Ref. PWA_22-1429

10th October 2022

**NON-MATERIAL AMENDMENT TO CONDITIONS 2 AND 6 OF PLANNING PERMISSION REF:
3/2021/1265
AT MANOR HOUSE, HOWGILL LANE, RIMINGTON, BB7 4EF.**

5364 -011 B

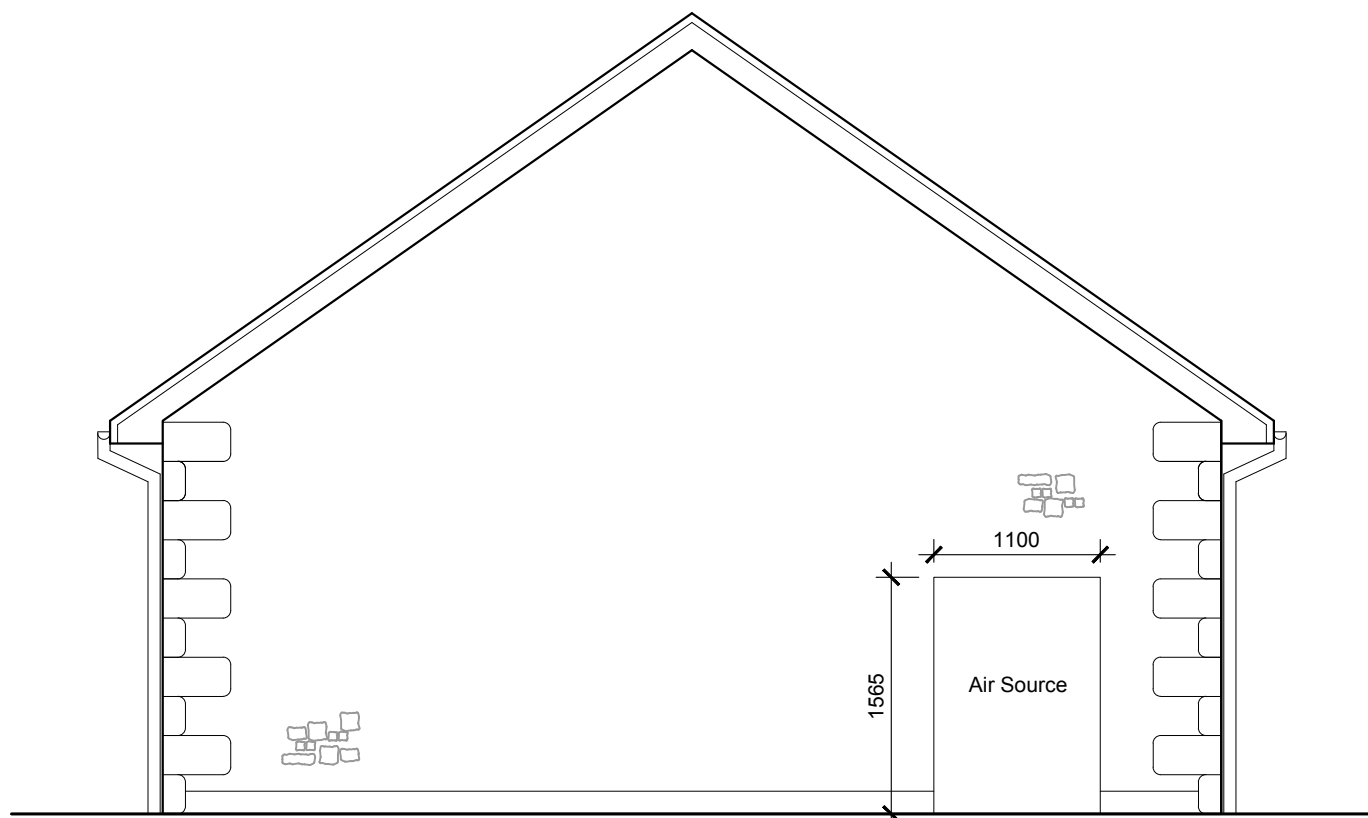
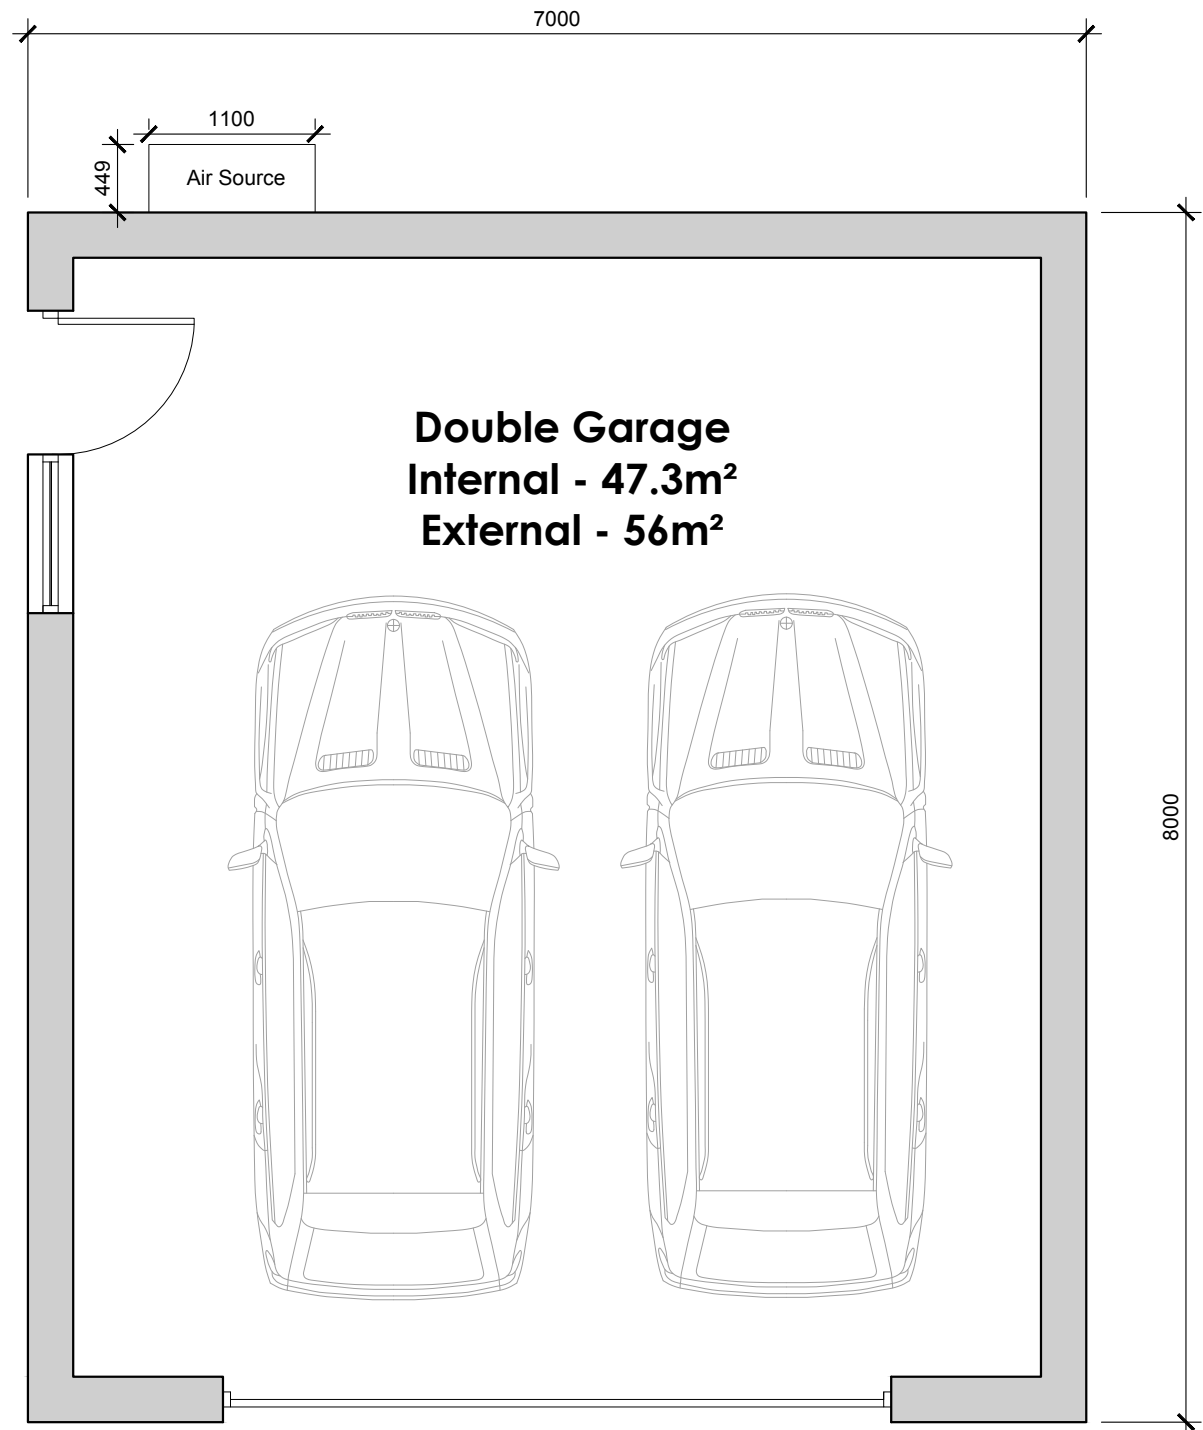
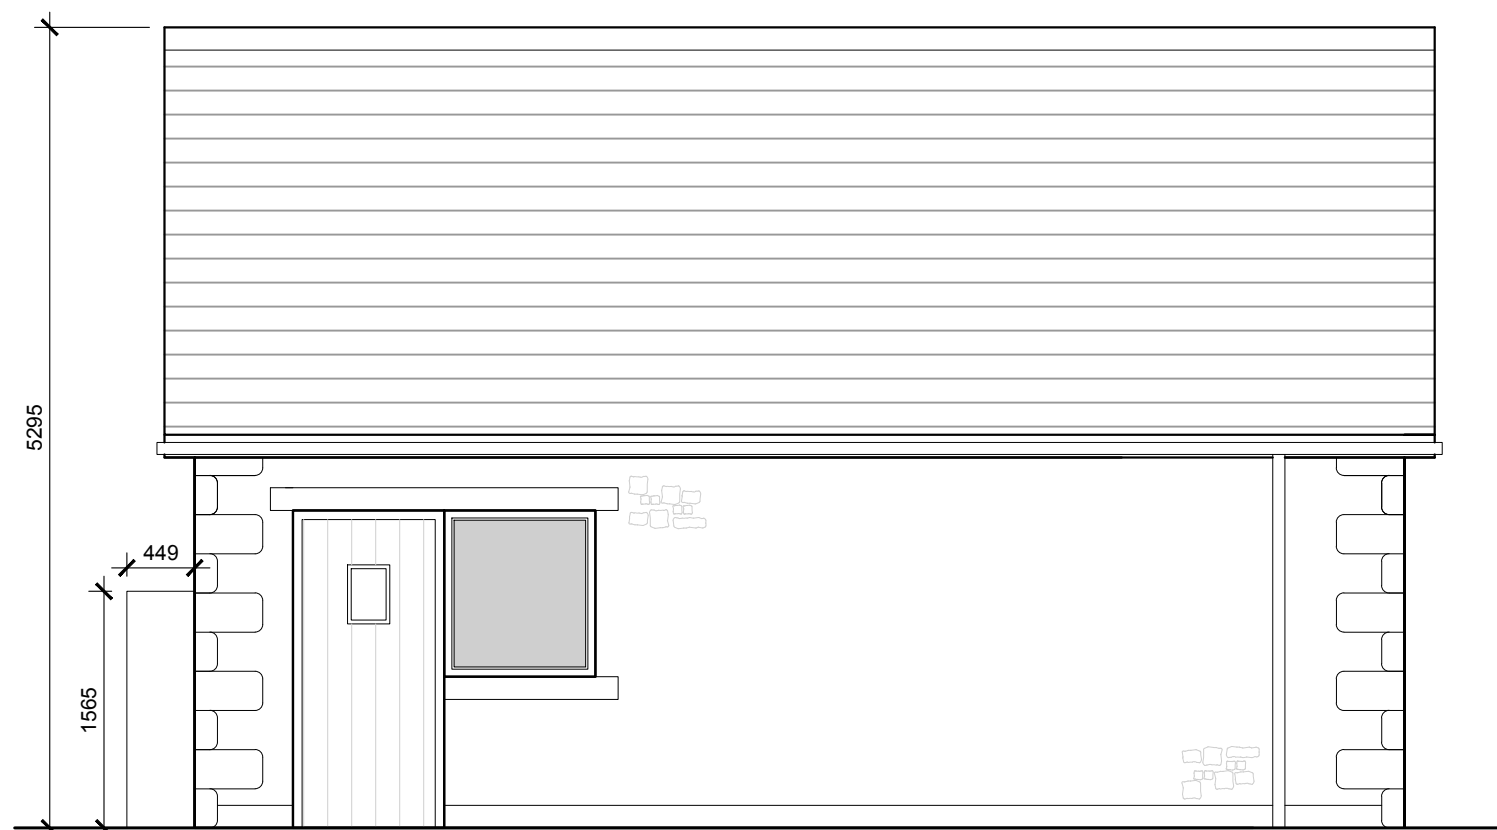
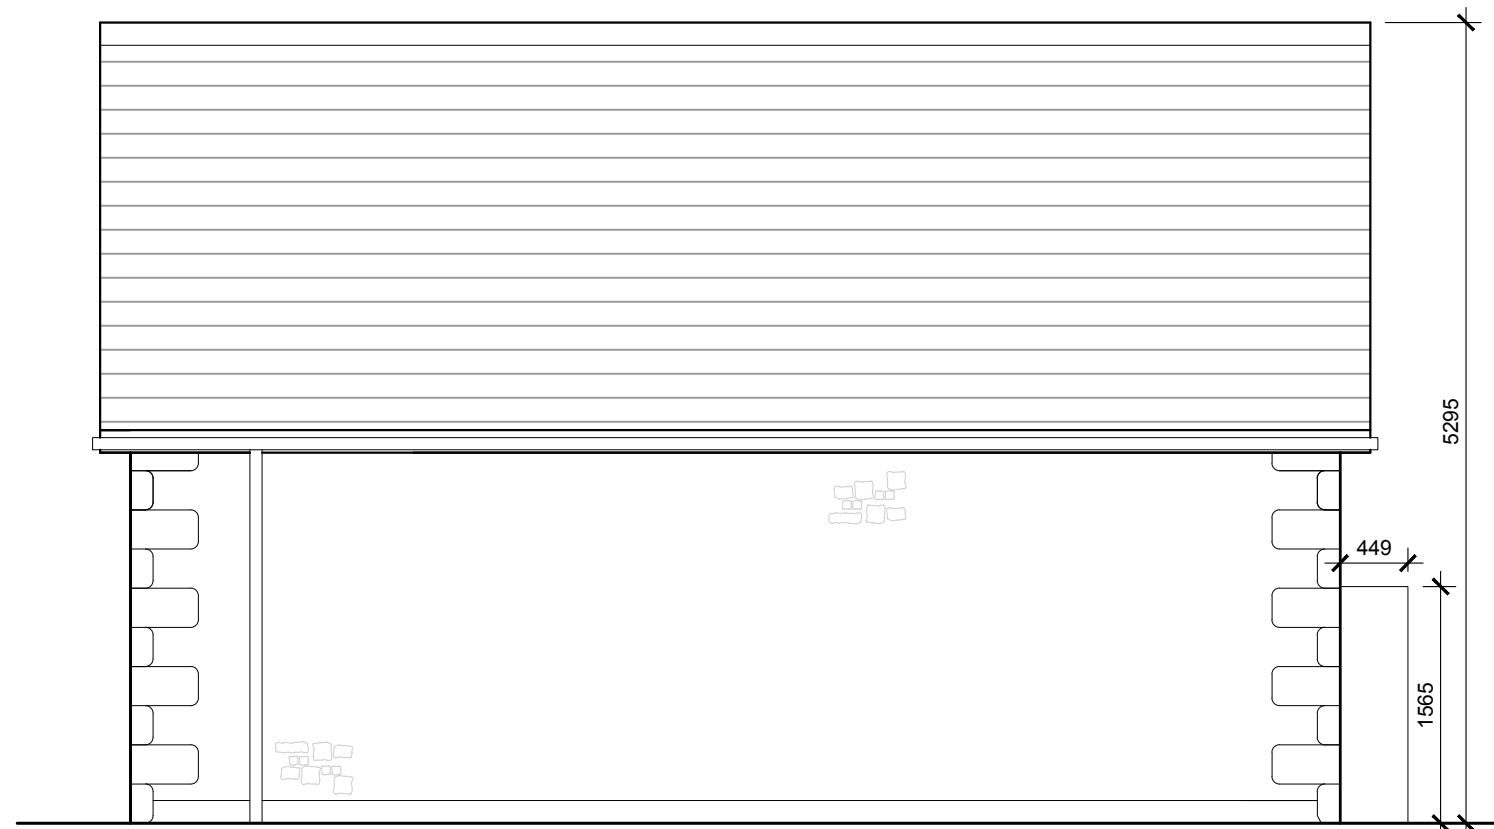
The applicants seek an amendment to the approved plans under Condition 2, to install an air-source heat pump to the rear of the approved garage. This will service this building as well as the main dwelling approved under application ref: 3/2018/0966.

As seen within the proposed plans, ref. 5364-011 B, the air-source heat pump would be located to the rear of the garage, on the north-western elevation. The pump would be obscured by the garage and the new converted barn, such that it would not be visible from the road. The pump will have a very limited visual impact on the surrounding area due to the small size of the unit and next to no impact on
